Ribble Valley Borough Council
Housing & Development Control

Your ref 3/2021/0771
Our ref D3.2021.0771
Date 14th April 2022

Application no: **3/2021/0771**

Address: **Tan Yard Farm Ribchester Road Hothersall PR3 3YA**

# PROPOSED SITE PLAN

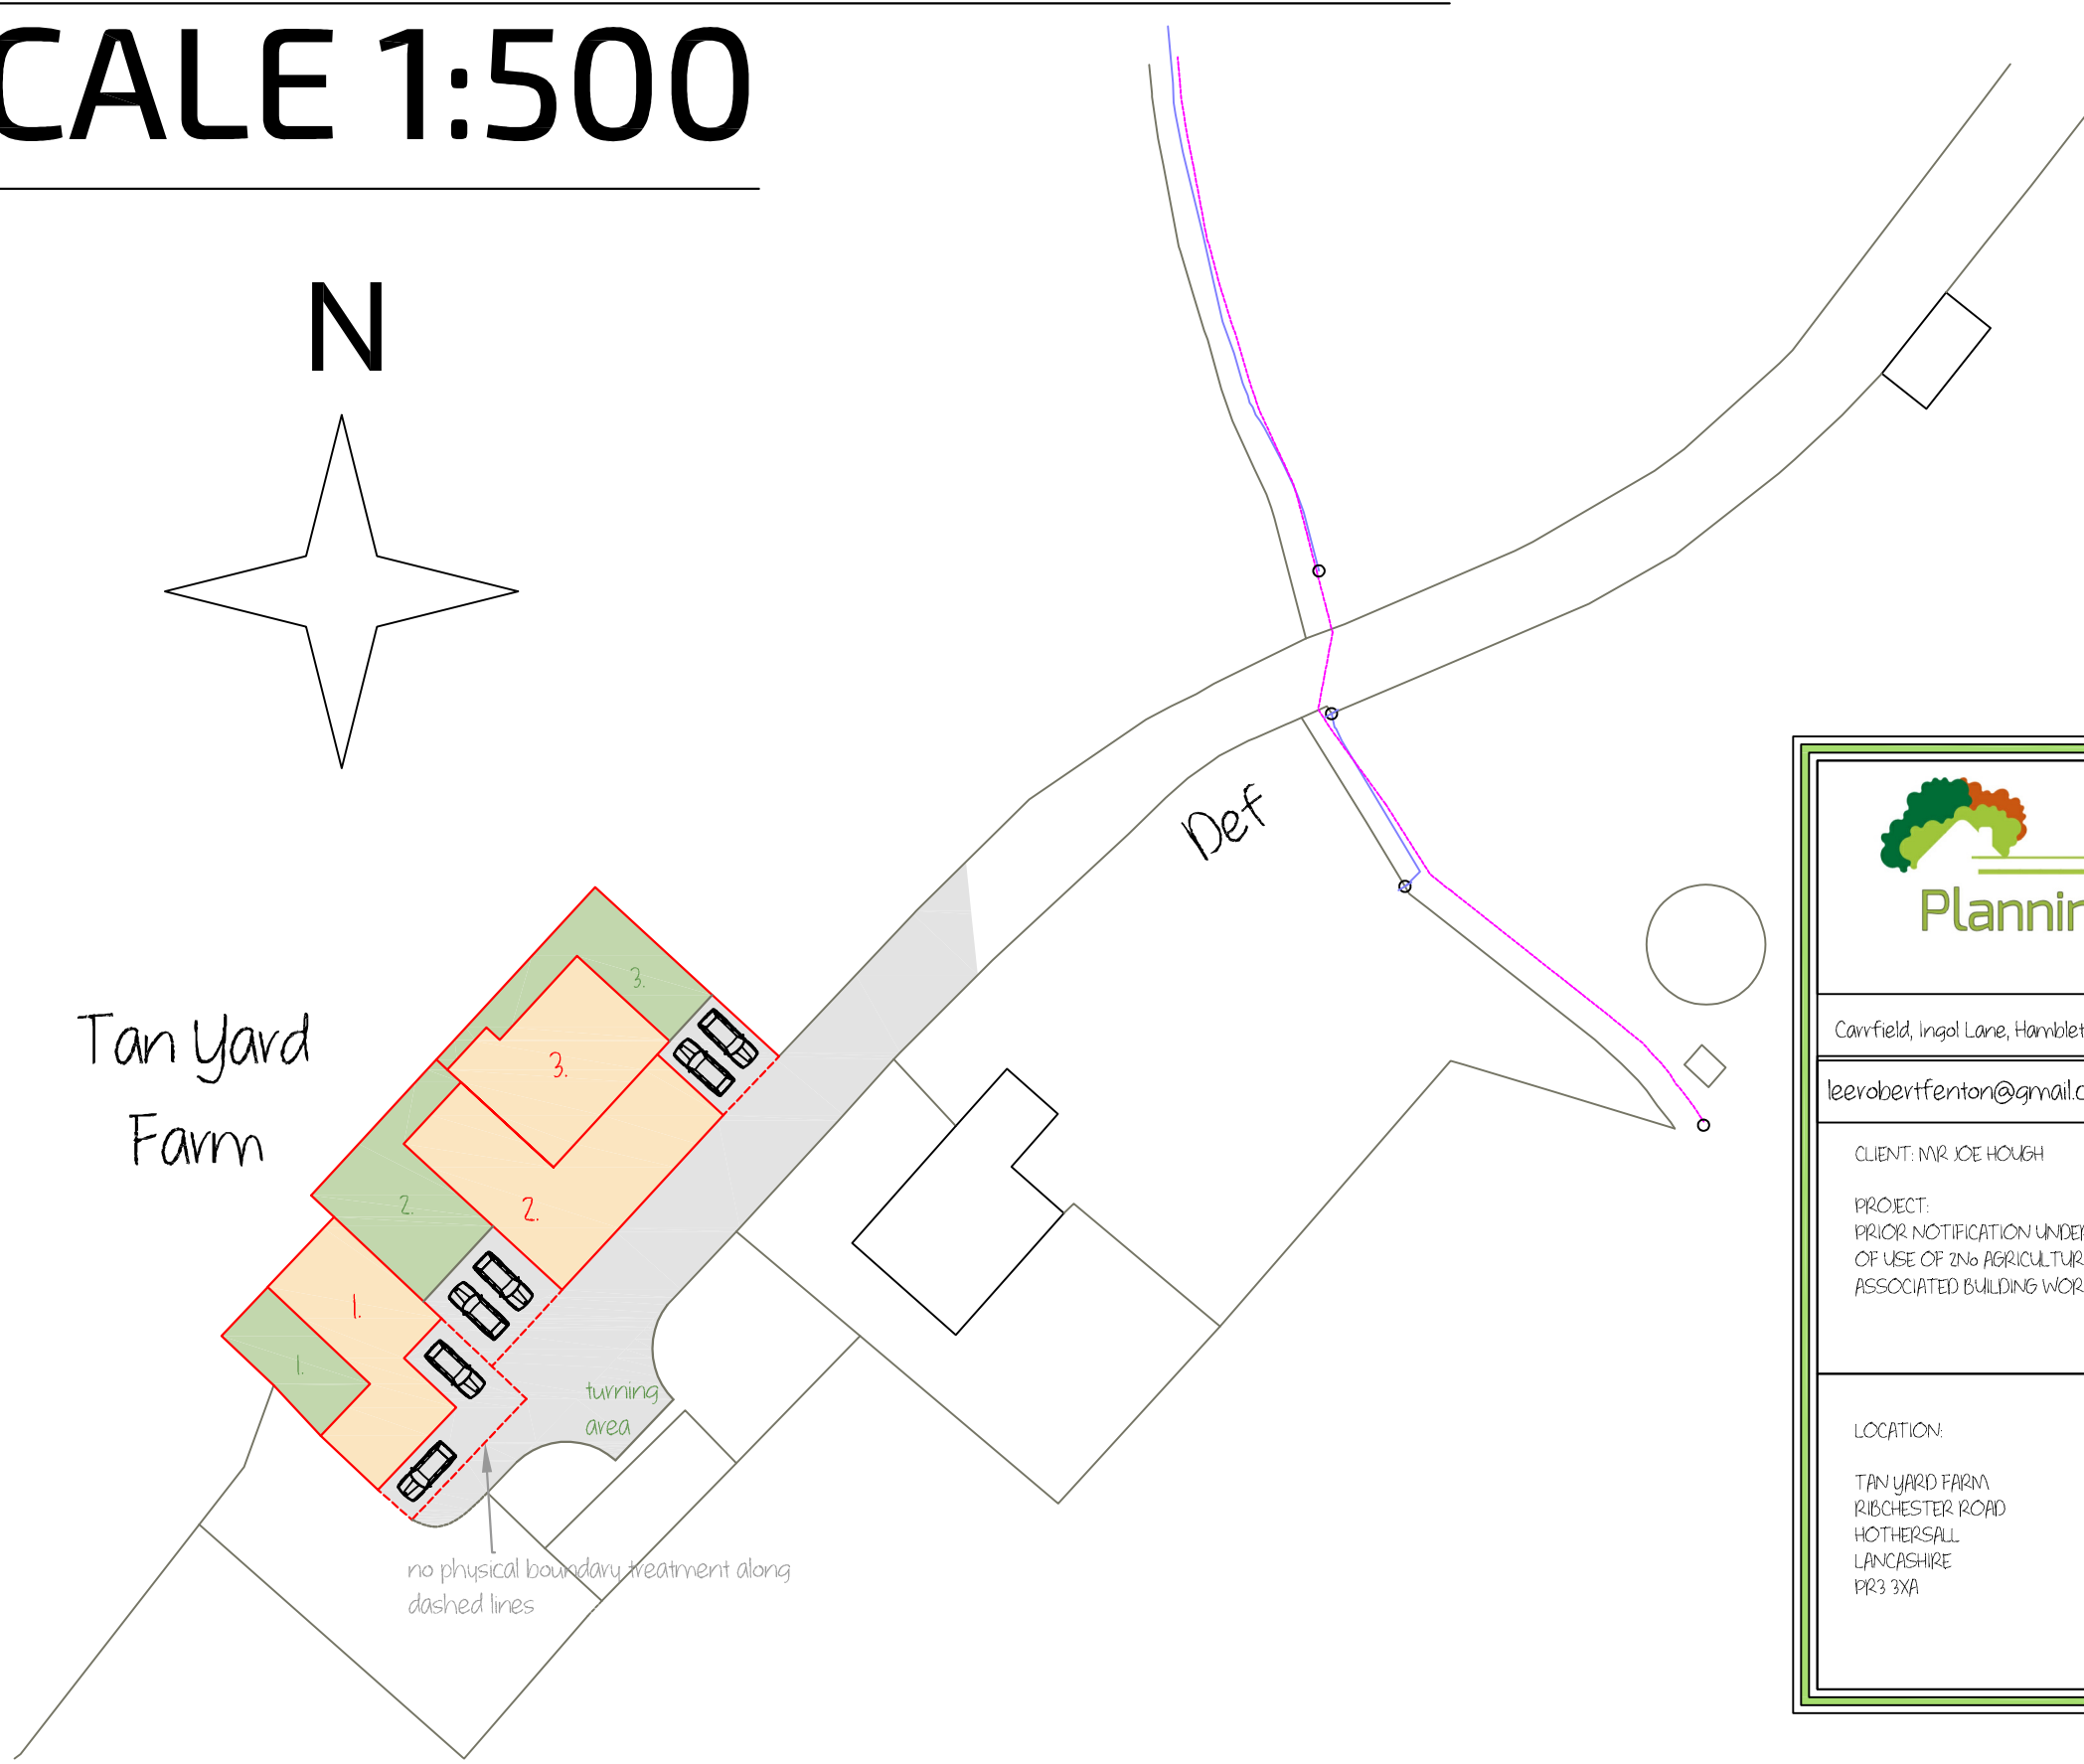
The LHA have reviewed Lee Fenton drawing number LF/JH/3603a titled "Proposed Site Plan" and understands that 2 car parking spaces per dwelling will be provided at the site. This complies with the parking guidance as defined in the Joint Lancashire Structure Plan and the concerns regarding the usability of the spaces, as stated in the previous comments, have now been resolved.

Before entering the field, the PROW does cross the Applicants red line boundary which is in their control and so conflicts with the parking arrangements for the unit. Therefore, the LHA advise the Applicant to contact the LHAs Public Right of Way team to discuss whether an alteration of the Public Footpaths definitive line is required before occupation of the site.

3. The development hereby permitted shall not be occupied until such time as the parking and turning facilities have been implemented in accordance with Lee Fenton drawing number LF/JH/3603a. Thereafter the onsite parking provision shall be so maintained in perpetuity.
